## STATEMENT IN RESPONSE TO AN BORD PLEANÁLA'S OPINION, FILE REF - 307307-20, WHITE PINES EAST SHD

FOR ASSESSMENT OF PROPOSED RESIDENTIAL DEVELOPMENT AT WHITE PINE  
EAST, STOCKING AVENUE, DUBLIN 16

This Statement has been prepared to address the issues raised by An Bord Pleanála (ABP) in the Opinion dated 7<sup>th</sup> October 2020 (Case Reference: ABP-307307-20) and issued subsequent to the Pre-Application Consultation stage of the subject SHD application at White Pine East, Stocking Avenue, Dublin 16.

WESTERN BOUNDARY CONDITION & SECTION

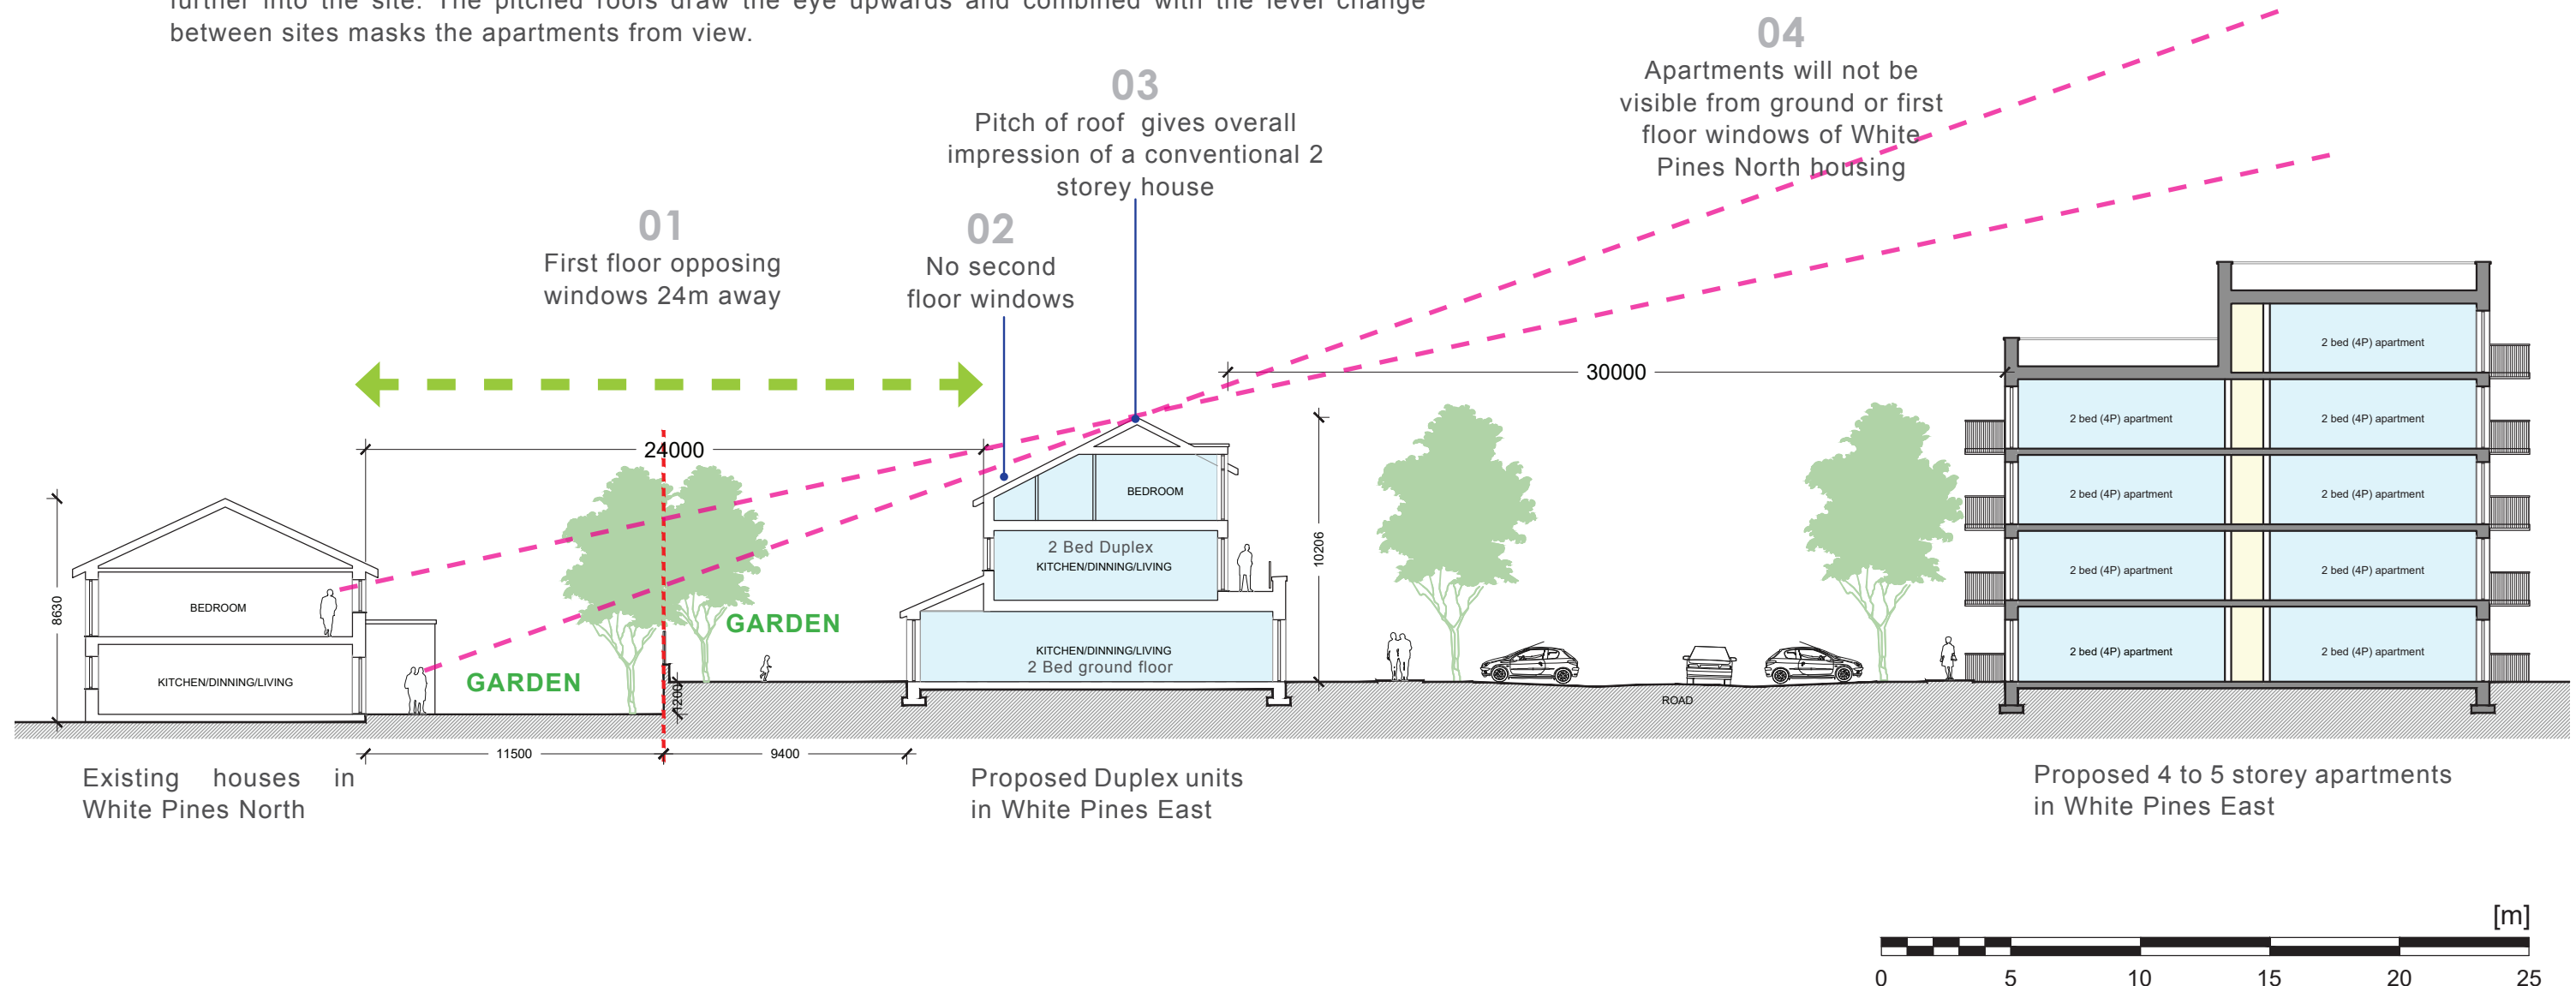
*A report that addresses issues of residential amenity (both existing residents of nearby development and future occupants), specifically with regards to daylight/sunlight analysis, overlooking, overshadowing, visual impact and noise. The report shall include full and complete drawings including levels and cross-sections showing the relationship between the proposed development and nearby residential development.*

04 PROPOSED DESIGN BLOCK A PLANS

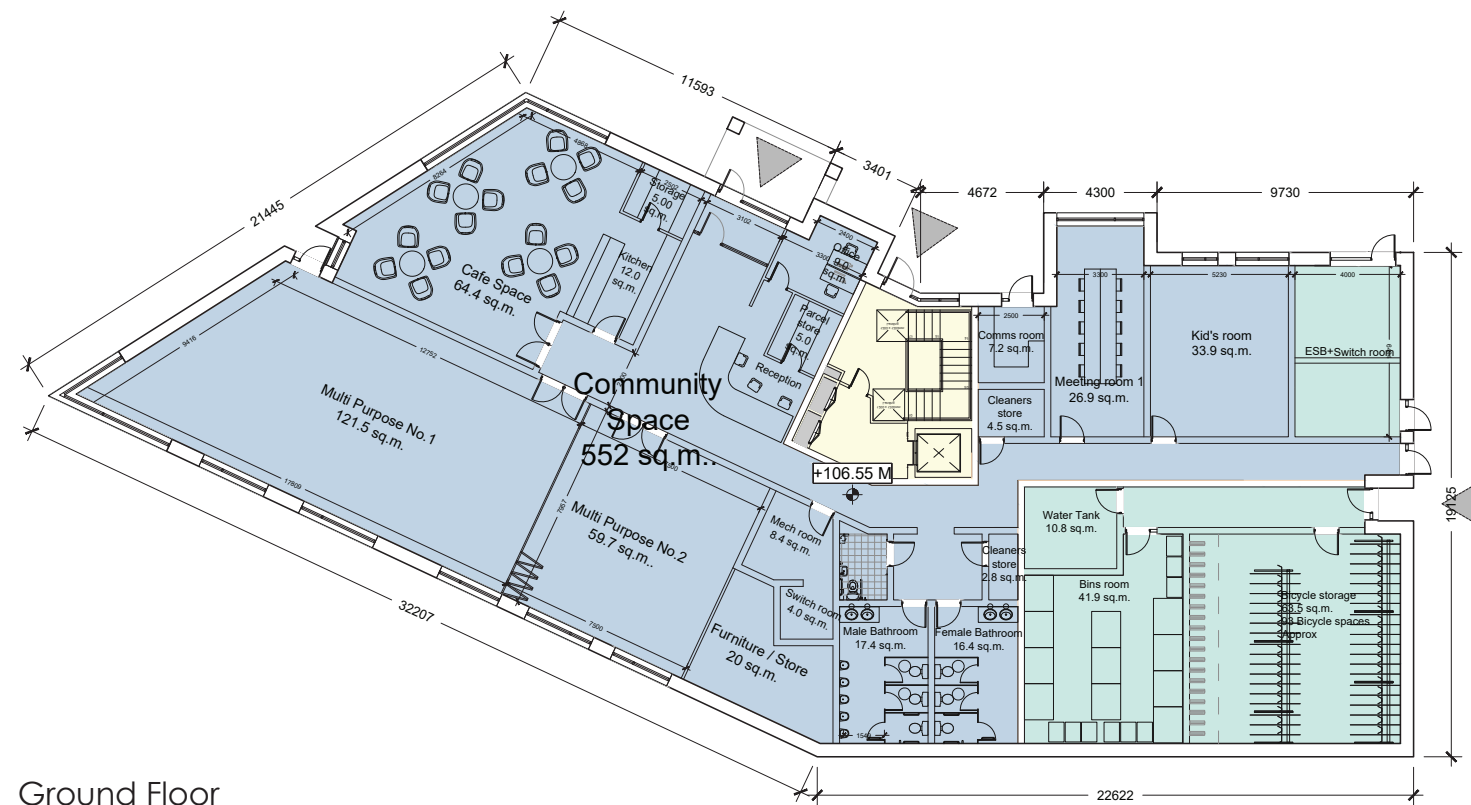
*Additional details and/or revised proposals in relation to the proposed community centre, having regard to the quantum of floor area proposed and the viability of same, and to the concerns as raised by the Planning Authority in relation to same.*

As noted in Section 2.1.1 above, the application submitted to the Board for pre-application consultation comprised the provision of a 195 sq.m community building, to satisfy the phasing requirements of the *BOLAP (2014)*. Following consultation between Ardstone Homes and South Dublin County Council, the subject application now proposes the provision of a c.552sq.m community building space located on the ground floor of Block A, at the site’s main entrance to Stocking Avenue. This enlarged space has been provided to provide a more substantial space for the local community.

The space will provide adaptable multi-function rooms, meeting room, Kid's Room, a shared kitchen/lounge space, administration space and ancillary spaces.
